RESPONSE TO SUBMISSIONS

LINDFIELD LEARNING VILLAGE (SSD 16_8114)

14 JUNE 2018
SA6386
FINAL
PREPARED FOR NSW DEPARTMENT OF EDUCATION

1 PROPOSED NORTH ELEVATION

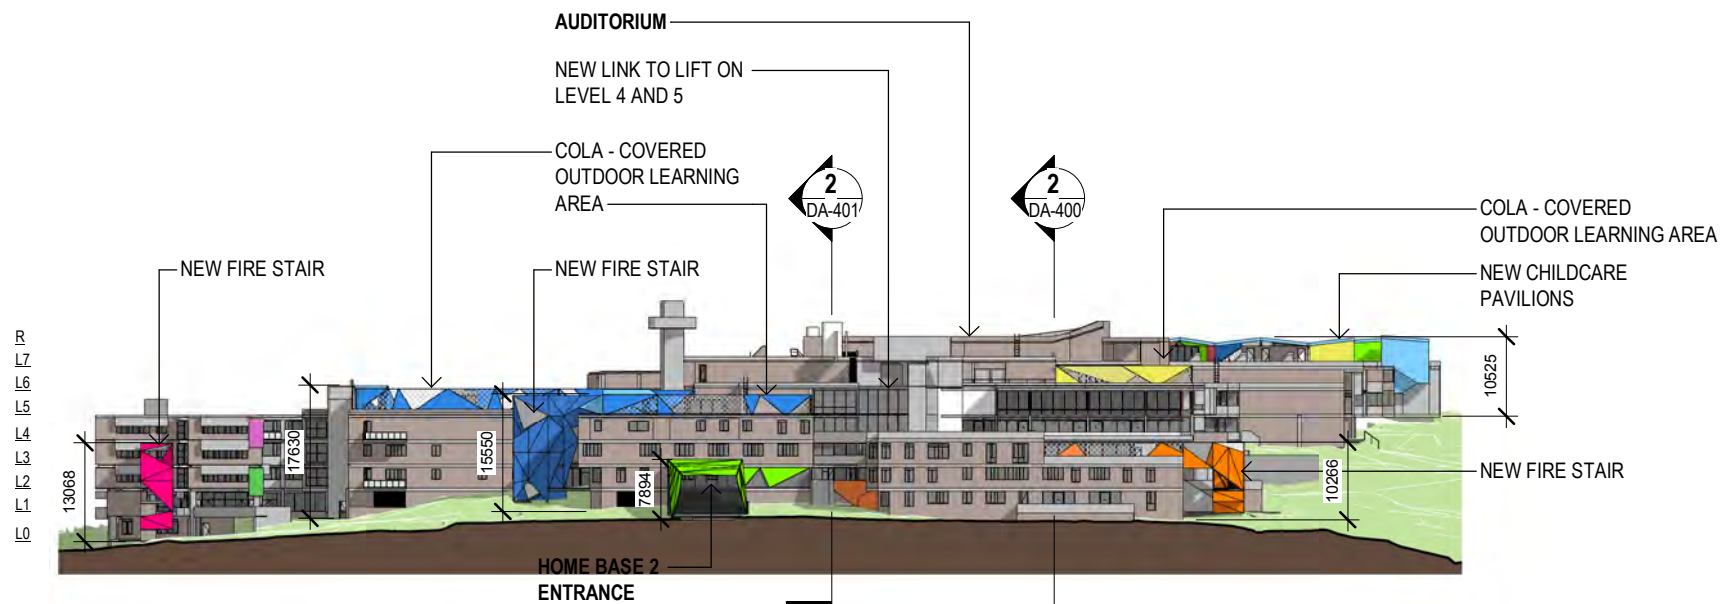
- The extent of 'coloured' external cladding has been reduced and has been applied to discrete areas of the external facades and covered outdoor learning area (COLA) structures to minimise the prominence and visual impact on the heritage significance of the building. **Figure 4** includes a comparison of the changes to the plans submitted with the EIS and the revised plans that accompany the RtS.
- The proposed landscaping and design of the rooftop terrace areas has now been resolved and is documented in the landscape plans that accompany the RtS.
- The proposal now incorporates a designated fire track around the southern perimeter of the site to provide adequate access for emergency services.
